Consultation Response from: KC Environmental Health (Pollution & Noise Control)		
2021/92427 - 48, Stile Common Road, Primrose Hill, Huddersfield, HD4 6DE		
Discharge conditions 9 and 10 on previous permission 2020/91228 for demolition of existing dwelling and erection of residential development to form student accommodation with associated access and parking		
Date Responded: 1st September 2021	Responding Officer: Natalie Heaney	Responding Ref: WK/202125277
Conditions 9 and 10 were recommended by the Coal Authority and relate to the Coal Mining legacy. Environmental Health were not originally consulted on previous permission 2020/91228. We acknowledge there is an overlap with Condition 9 as the coal mining legacy features may present an environmental health risk (e.g. from mine gases or combustion). Condition 10 relates to surface stability. This is outside the remit of Environmental Health. Condition 9 – Intrusive Site Investigation Works (Coal Mining Legacy) In our previous response dated 13th August 2021, we commented on a Coal Investigation report by Rogers Geotechnical Services Ltd, dated 10th June 2021 (ref: C337/20/E/1956). We stated that due to the presence of shallow coal

Not to scale.
Investigation positions are approximated from site notes.

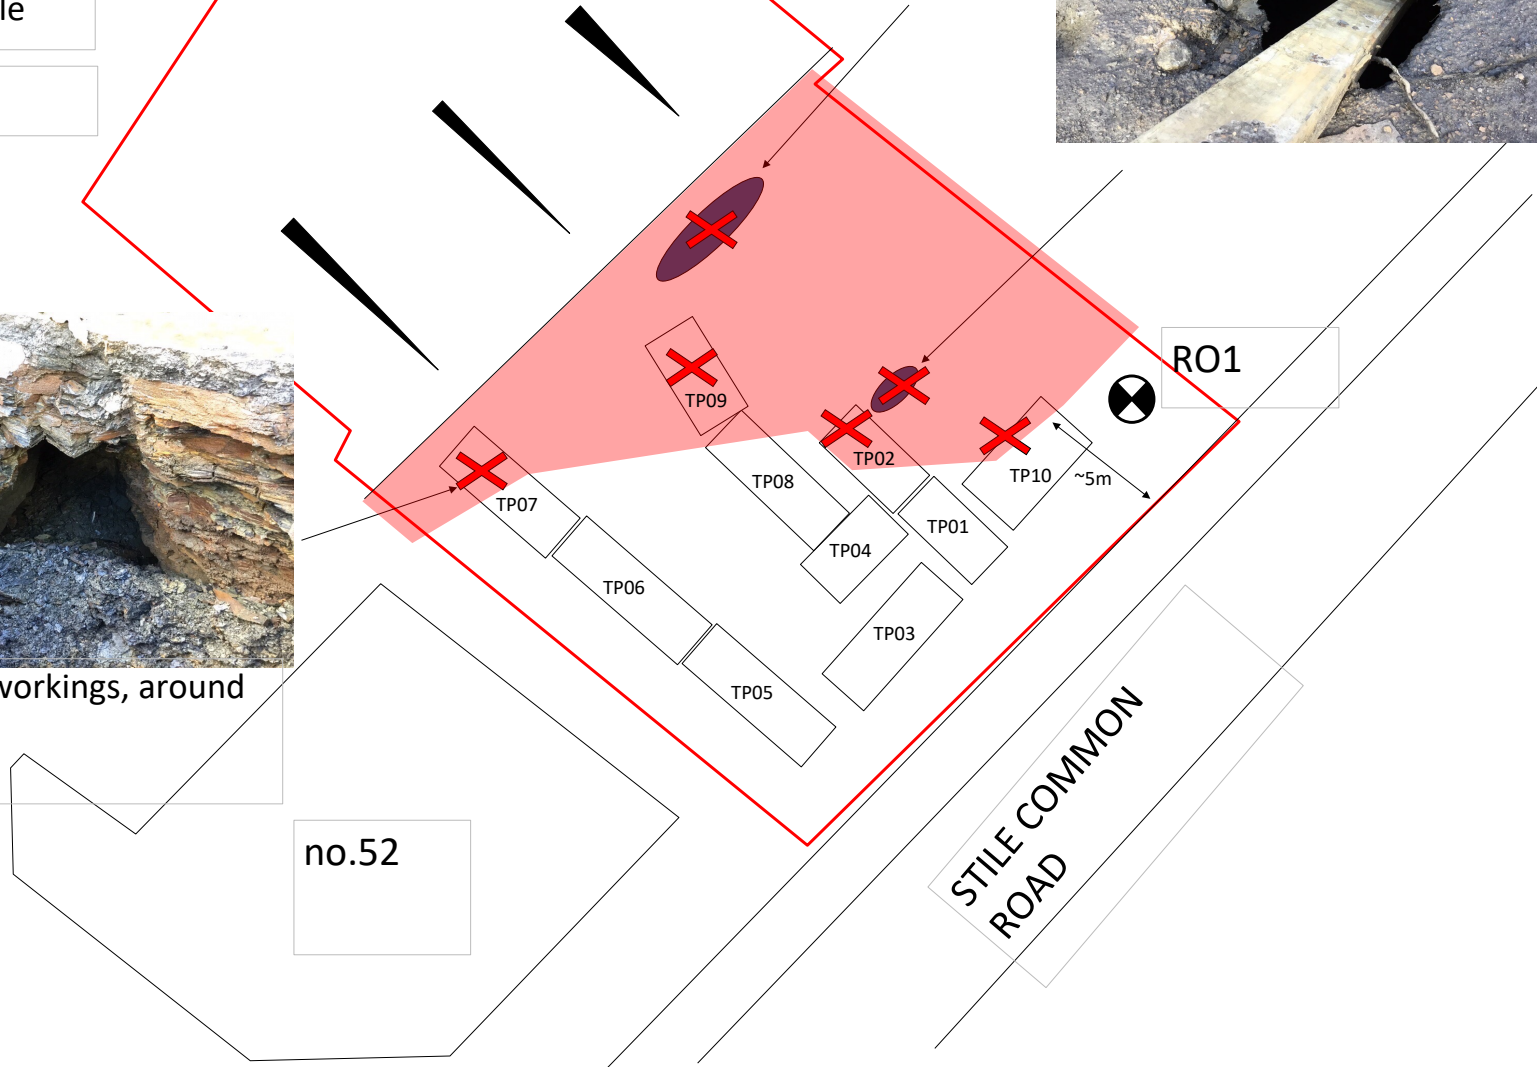
2. The original report (ref: C337/20/E/1956) provided information from 'RO1'. The addendum report (ref: C337/19/E/GM) discusses data from a 'BH01'. This does not appear consistent, and it is unclear whether BH01 and RO1 are the same as no supporting map has been provided in the addendum. Further clarification is required.

3. Additional justification is required for the placement of RO1/BH01 (see point 2). Not only does the placement of a singular borehole appear to be in discord with the current guidance as raised in Point 1, but RO1 is in the far corner of the site where what appears to be visitor parking is proposed. It is unclear why no further boreholes were placed whether the building footprint is proposed. The additional justification for site methodology must be in accordance with BS10175 guidance and other best-practice guidance.
